Application No:3/2022/1039

Land adjoining 115 Kemple View

29<sup>th</sup> November 2022

Please find my concerns, observations on the proposed development.

1 PROPOSED SOUTH-WEST
1 : 100

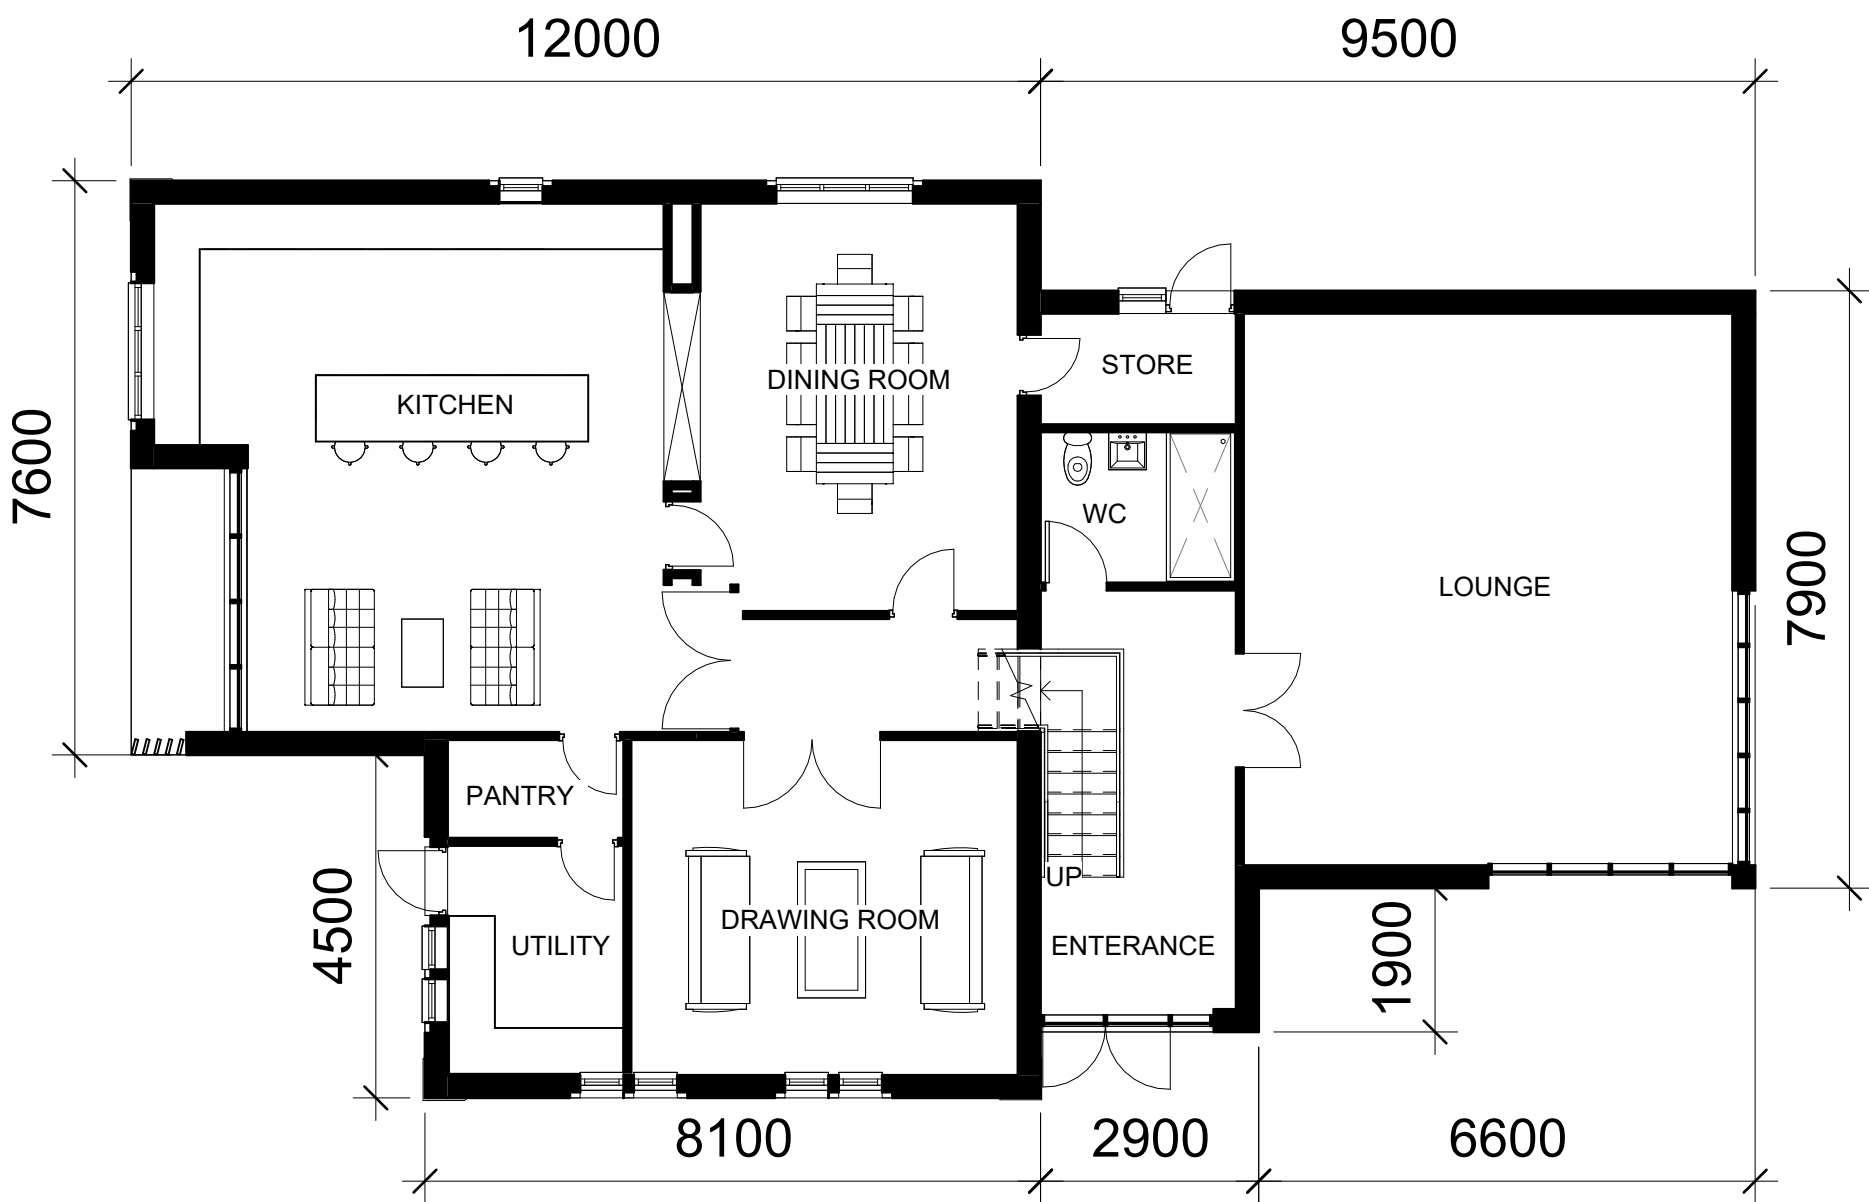
To the casual observer the property designs seem at odds with the surrounding properties and in fact looks more like a Care Home Complex rather than two family homes.

1 PROPOSED SITE PLAN 1
1 : 200

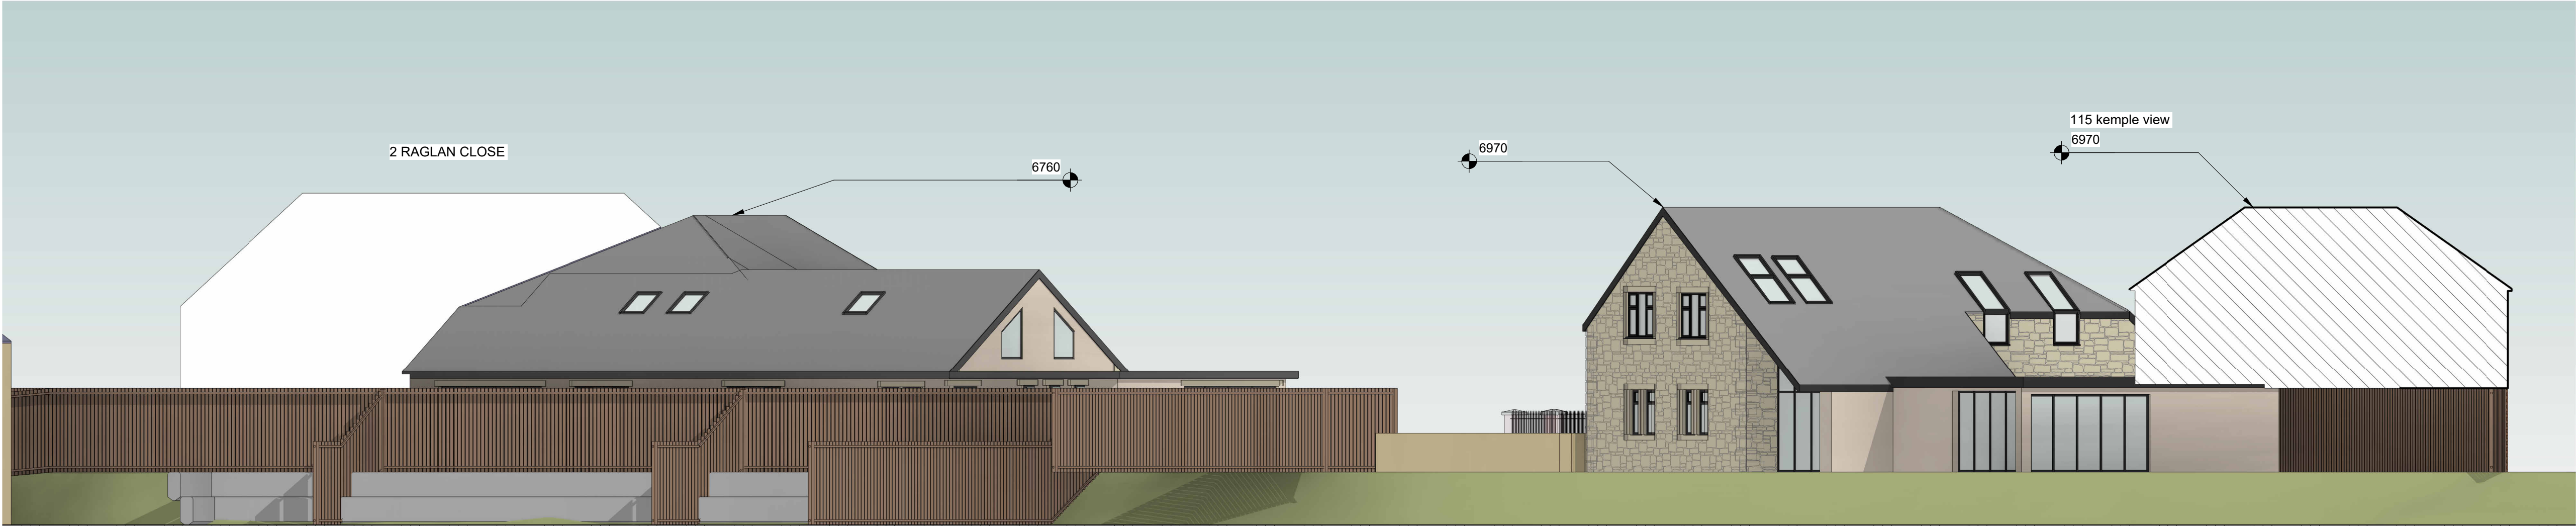
[REDACTED] with the proposed development yet there is still no discernable plan for the actual entrance i.e. between Kemple View and the proposed development. I find it difficult to understand how this so narrow entrance is legally permissible, certainly lorries will need to mount the pavement to gain entrance.

I am concerned that the large gravel area is designed to accommodate far more than the stipulated 6 cars and once built I can see no way the council would be able to enforce their conditions.

Perhaps the council could persuade the developer to move the entrance to come in from the side adjacent to the other new developments.

I would wish to comment later when their plans for the entrance, the public footpath and the shared boundary are made clear.
